# Chapman Agritainment

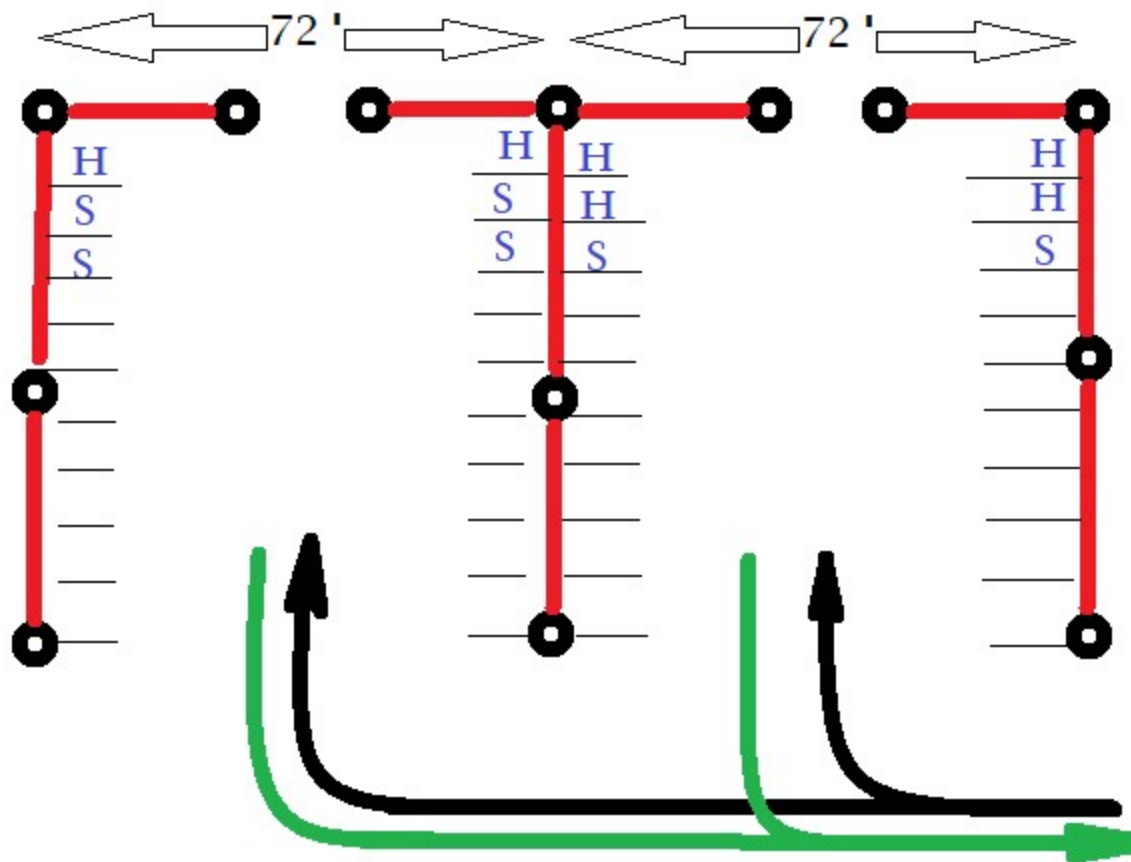
Please show the floodplain. Refer to attached document showing the limits of the 100 year floodplain on the parcel

Show setbacks from structures to closest parcel boundary.

Identify the surface type for the proposed parking lot and driveway access.

Please call out existing vs. proposed structures, surface type of parking and driveway, and permanent vs. temporary structures.

Please call out if face painting has a permanent structure. Is this just a removable table?

Show all existing structures.

Show Right of Way Easement as stated in the Title Commitment

Please include the dimensions of the proposed parking area and driveway access. If the area of the proposed parking lot, driveway access, and structures is at or exceeds one acre, then the following will be required to be submitted:

- Grading and Erosion Control Plan (GEC)
- Erosion and Sediment Quality Control Permit (ESQCP)
- Stormwater Management Plan (SWMP)
- Financial Assurance Estimate (FAE)
- Permanent Stormwater Quality facility
- Maintenance Agreement for the permanent stormwater quality facility.
